# Summary of Comments on 2007-212-SUB2-PLANS\_review.pdf

Number: 1 Author: Tree Review (john.kenney@mercergov.org) Subject: Sticky Note Date: 4/23/2021 11:39:31 AM

**FOREST CREEK ESTATES LOT 4 PERMIT SET**  
5202 FOREST AVE S.E.  
MERCER ISLAND, WA 98040

1 LOT 4 TREE PLAN
SCALE: 1/8" = 1'-0"

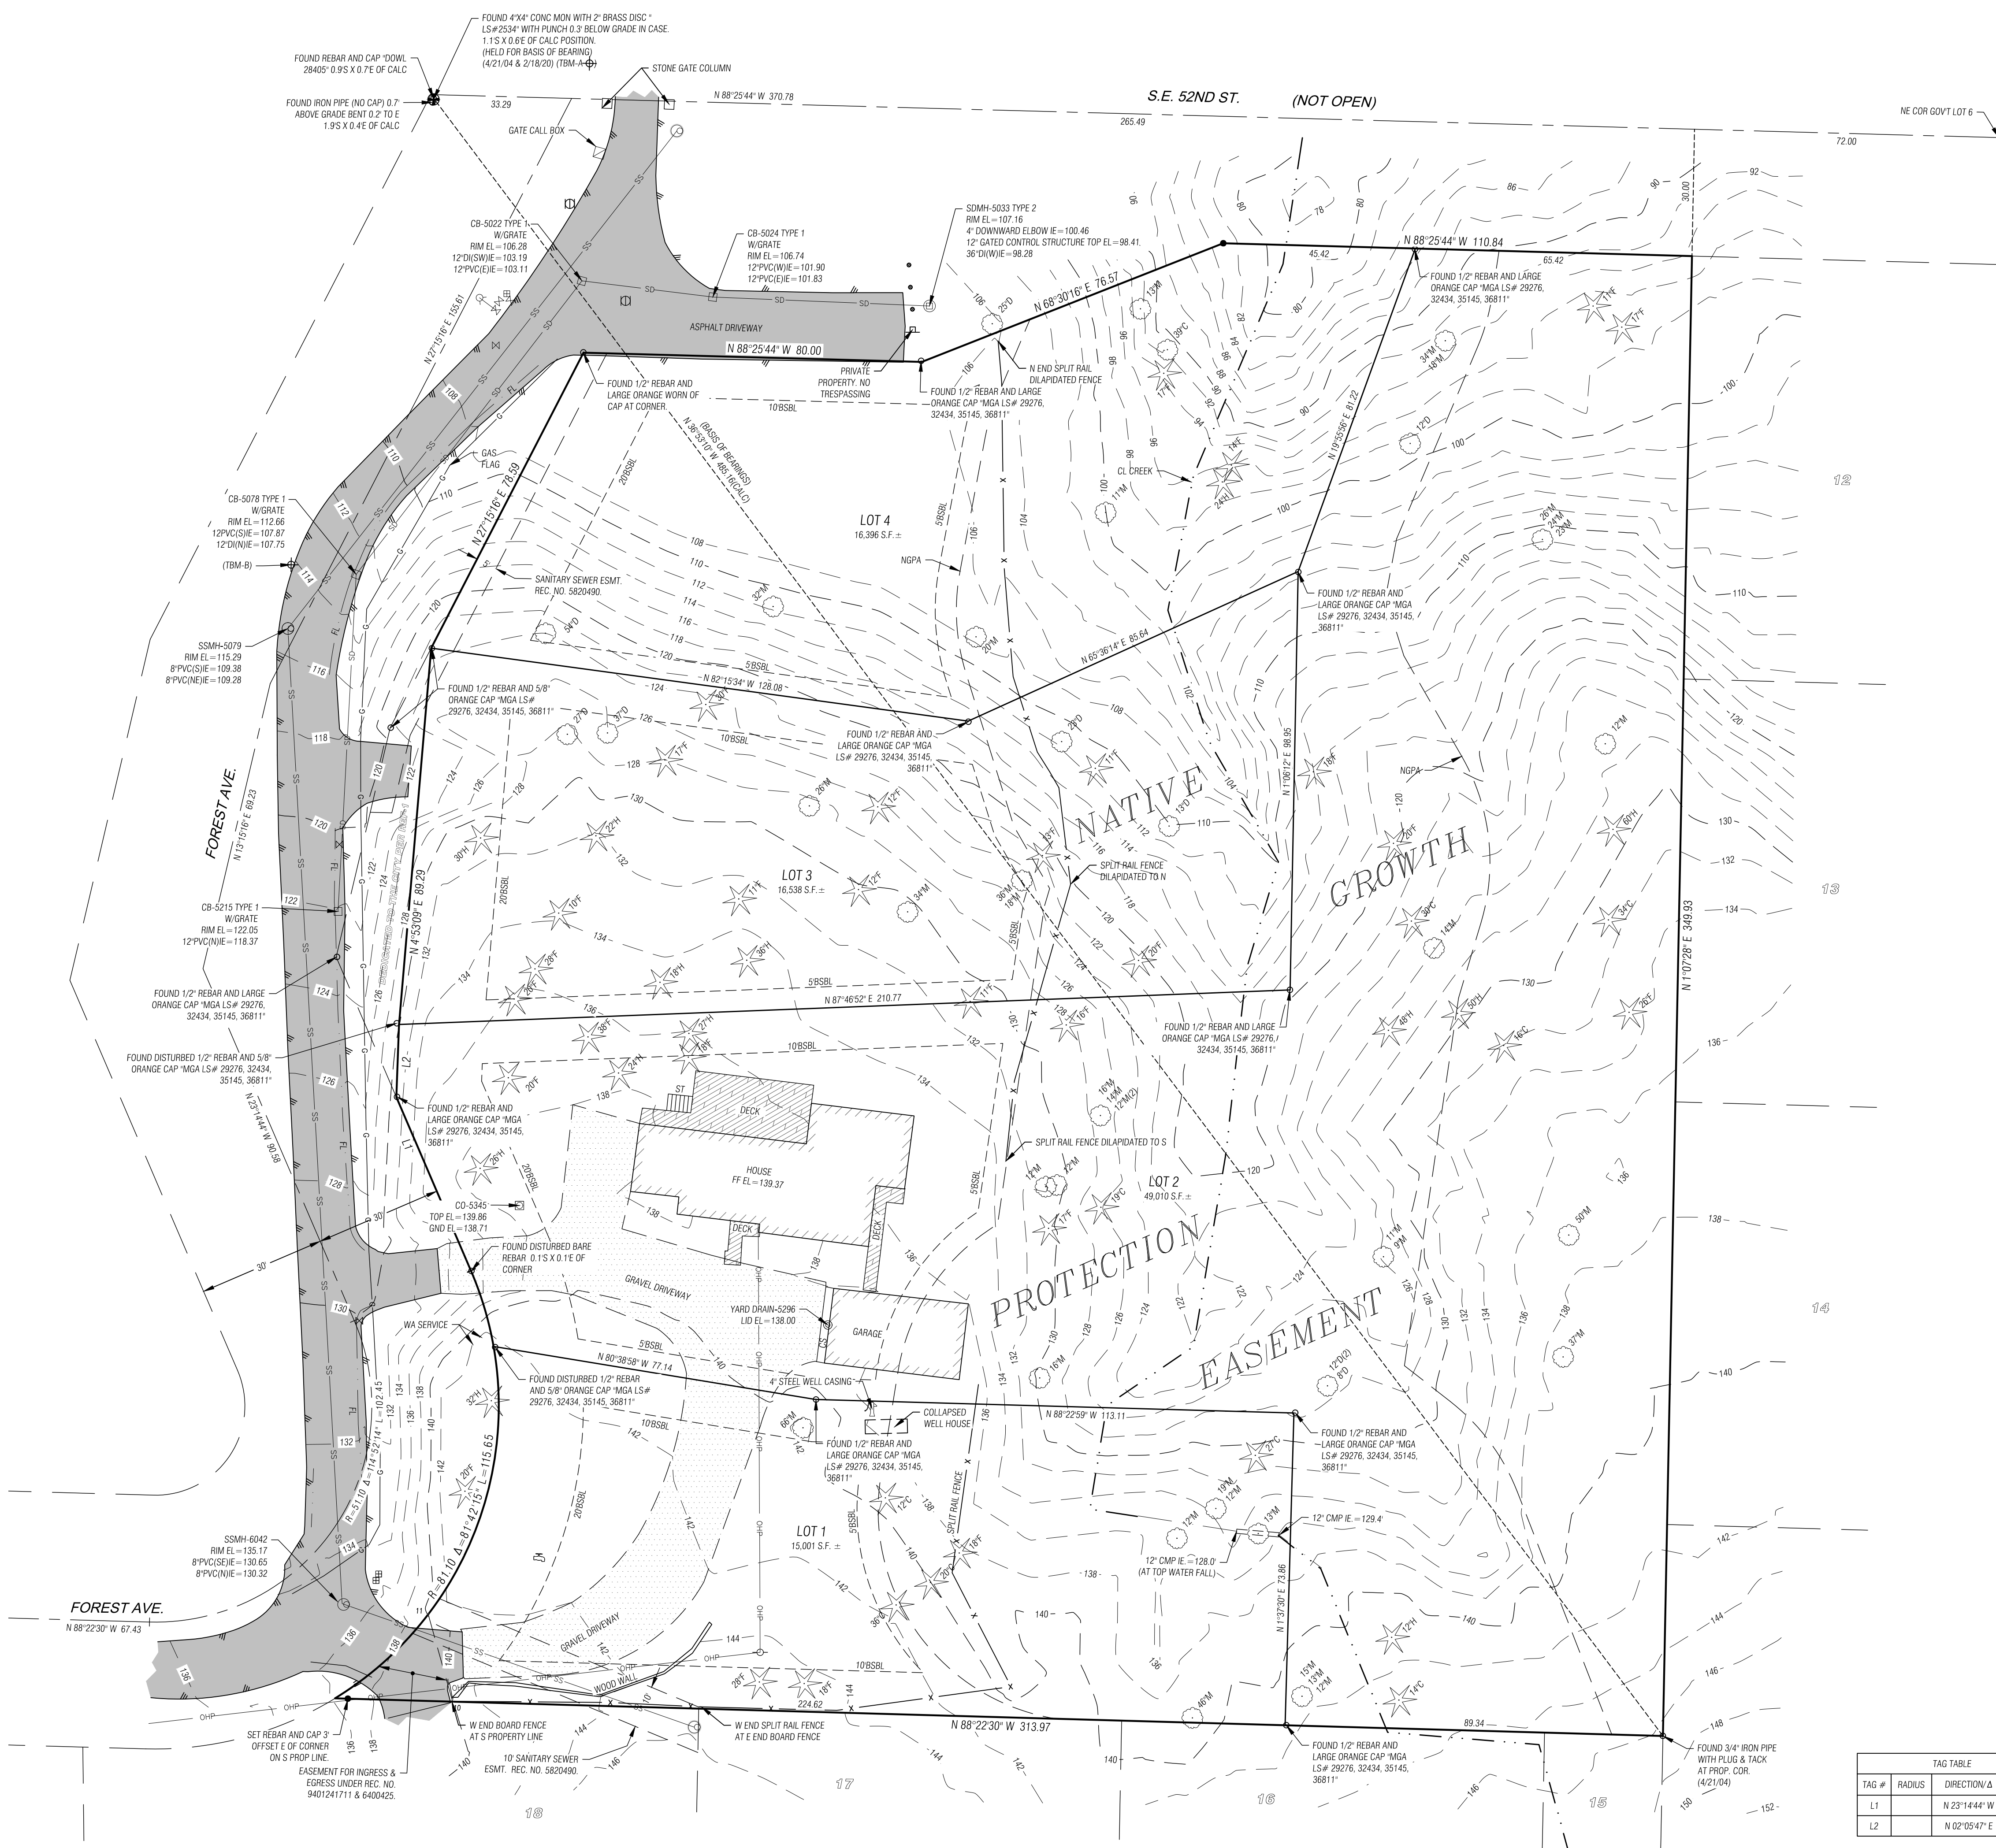
6. New comment because of change of plan sheet A1.2. Excavation limits have increased from sub-1. Adjacent properties Trees 301,302,319,321,320, 315 are now shown for removal in sub-2. Remove X though all trees that are not required to be removed for this retaining wall. All exceptional trees that have not been noted to be hazardous will need justification for removal per 19.10.060.A.2 (trees 302,315,319). Grading plan C1.0 does not show this over excavation shown on site plans and shows this minimized grading can work. Update A1.1 and A1.2 to reflect the grading plan. Only 2' of over excavation required over property line per grading plan.

Tree 315 shown on A1.2 only and not on C2.0. Also A1.2 includes removal of 314 (also not shown on C2.0).

C2.0 TESC Plan shows limits of grading; all trees noted are required to be removed to construct the retaining wall.

Noted - Arch to address.
